**WEST SUSSEX COUNTY COUNCIL
 STRATEGIC PLANNING CONSULTATION**

SUBJECT: EP/40/12

9 x flats with associated parking & amenity space following demolition of existing buildings.

115-117, Sea Road, East Preston, West Sussex, BN16 1NX

drawing: Ground Floor Plan
scale: 1:200 @ A3 date: Dec '11

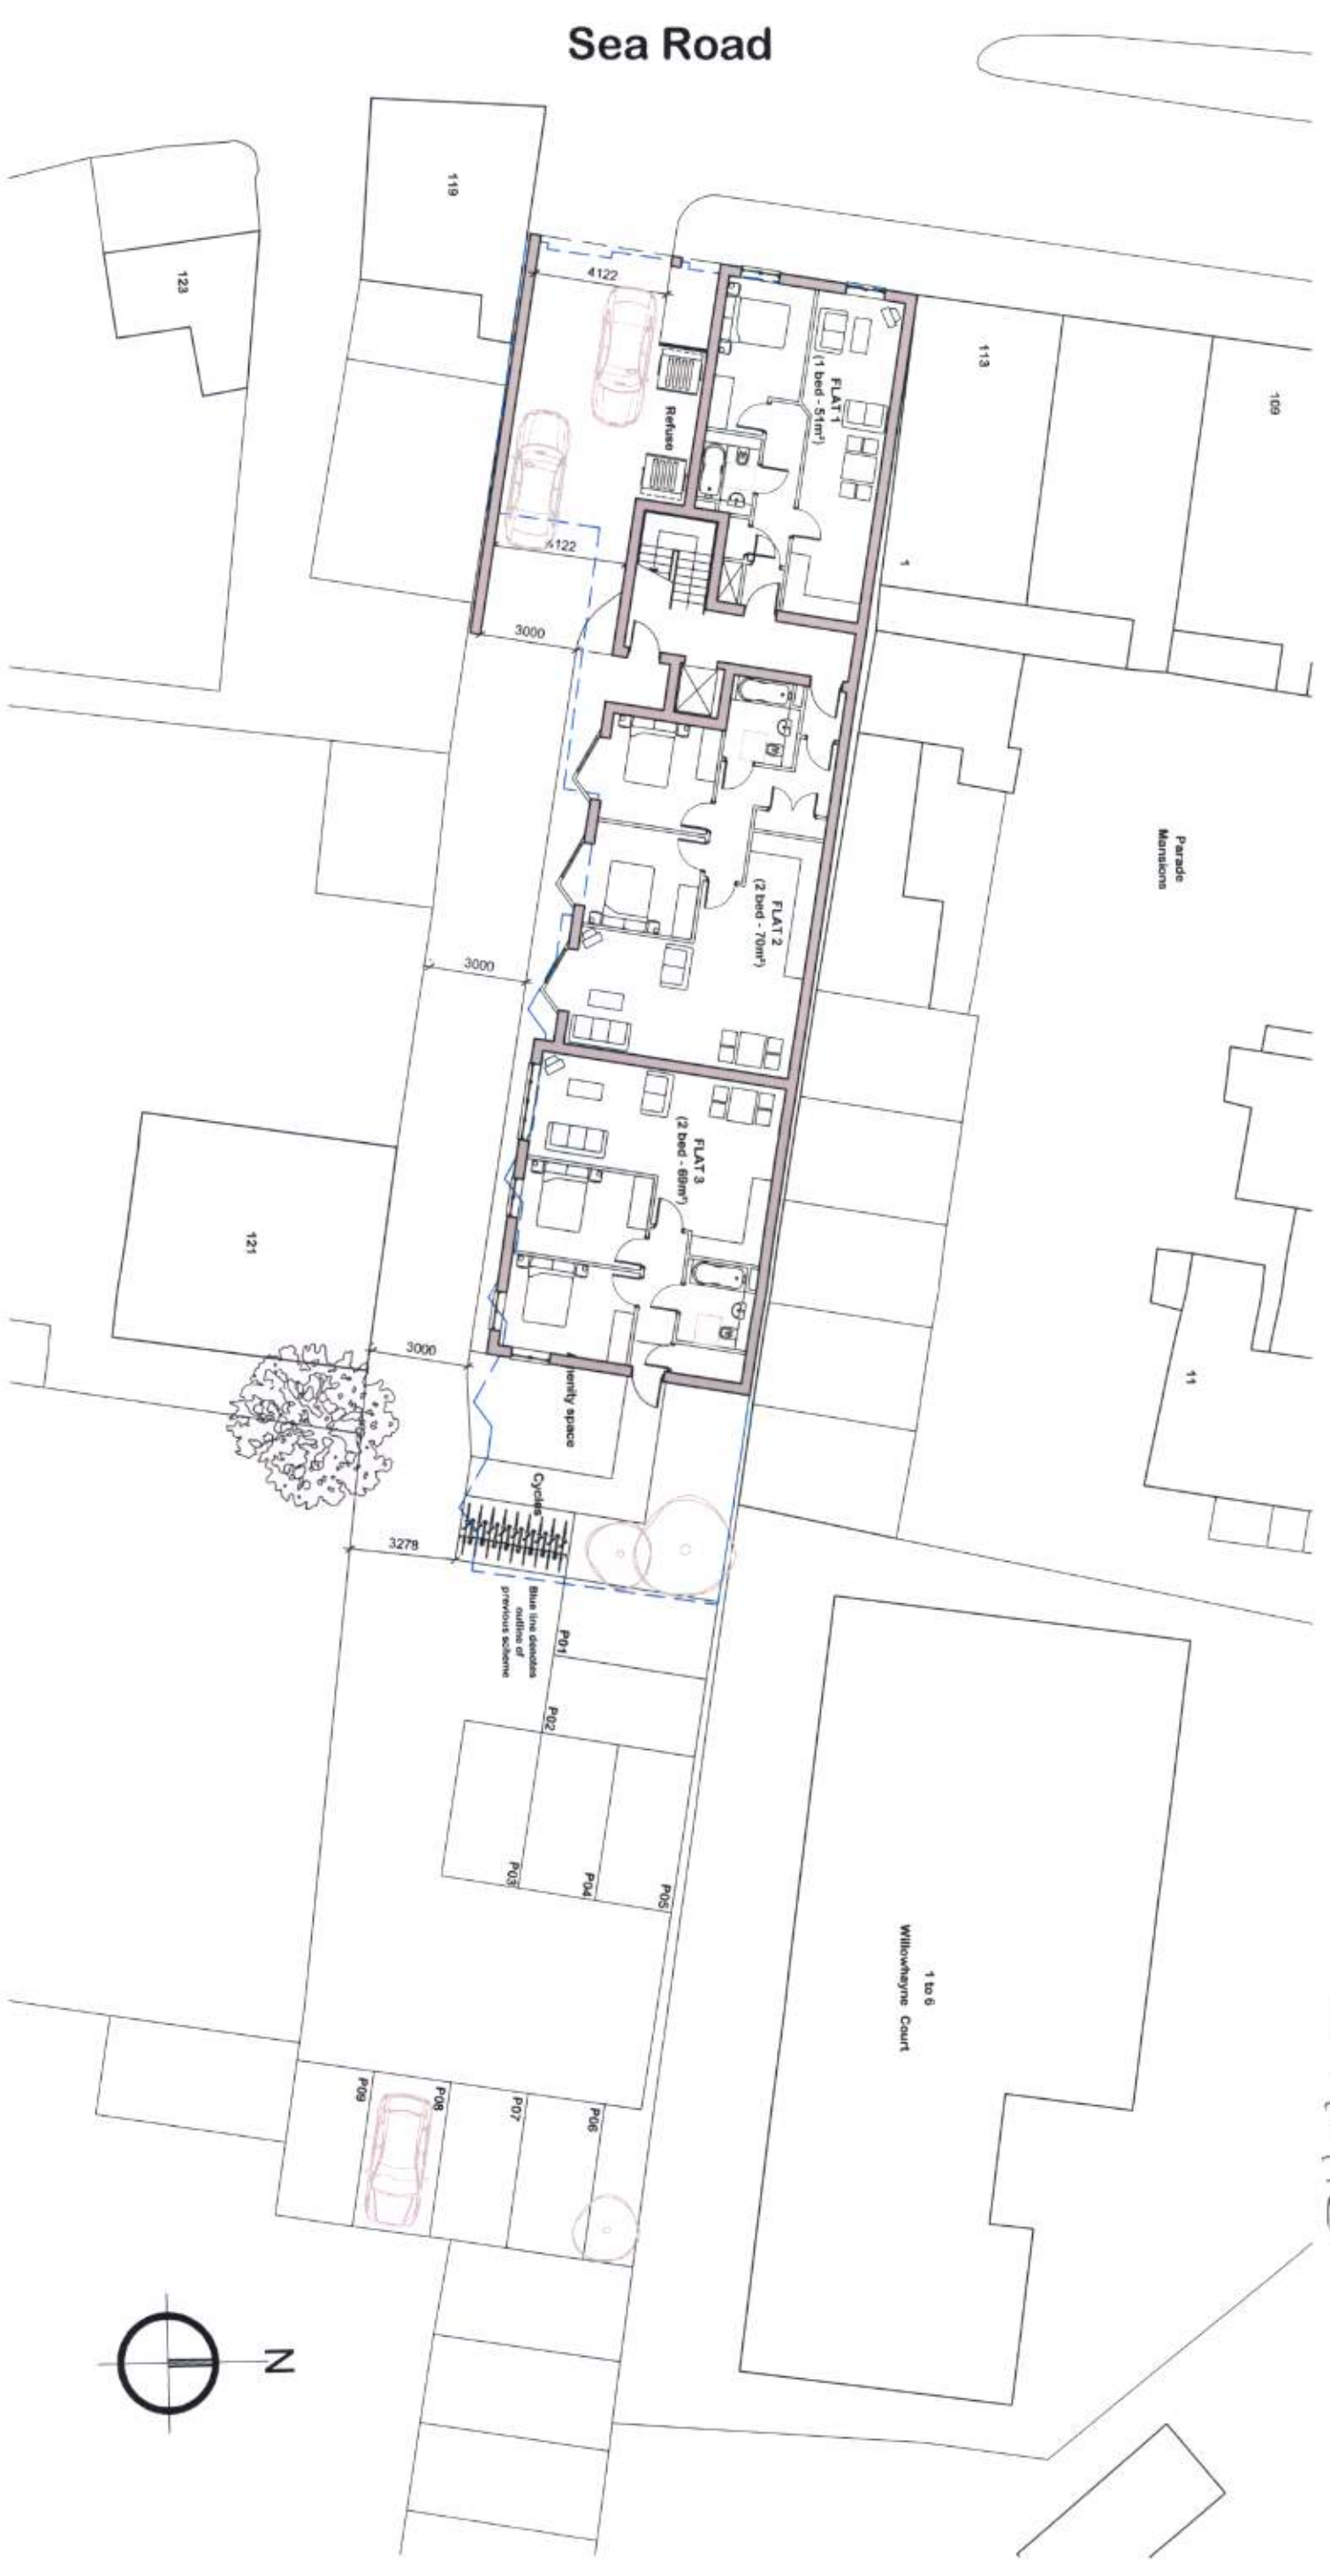
The access has been demonstrated to have a width in excess of 4.1m for approximately the first 12m. This is sufficient to enable two cars to pass one another clear of the Highway before the access narrows to a width of 3m. Given the low generation nature of such a development, the requirement for 2 vehicles to use the access at once will be infrequent. An officer representing the Fire and Rescue Service has advised that there is sufficient access for the attendance of emergency vehicles.

It remains unclear whether the removal of garages will result in the displacement of parking and further on-street demand. Likewise, it is unclear as whether parking will be left unallocated; however, the WSCC Parking Demand Calculator would suggest that 8 spaces of unallocated parking would be required, rising to 12 should 1 space be allocated per dwelling. Consideration should be given as to whether there will be an increased demand for on-street parking facilities, however, it is not expected that the parking provision will result in a Highway safety concern given the close proximity of the site to a car park and the presence of parking restrictions.

No dwelling, hereby approved, shall be occupied until the car parking spaces have been provided,

surfaced and marked out in accordance with a detailed construction plan to be submitted to and approved by the planning authority. These spaces shall thereafter be retained at all times for their designated use.

No dwelling, hereby approved, shall be occupied until a turning area has been provided, surfaced and marked out in accordance with a detailed construction plan to be submitted to and approved by the planning authority. This turning area shall thereafter be retained at all times for their designated use.
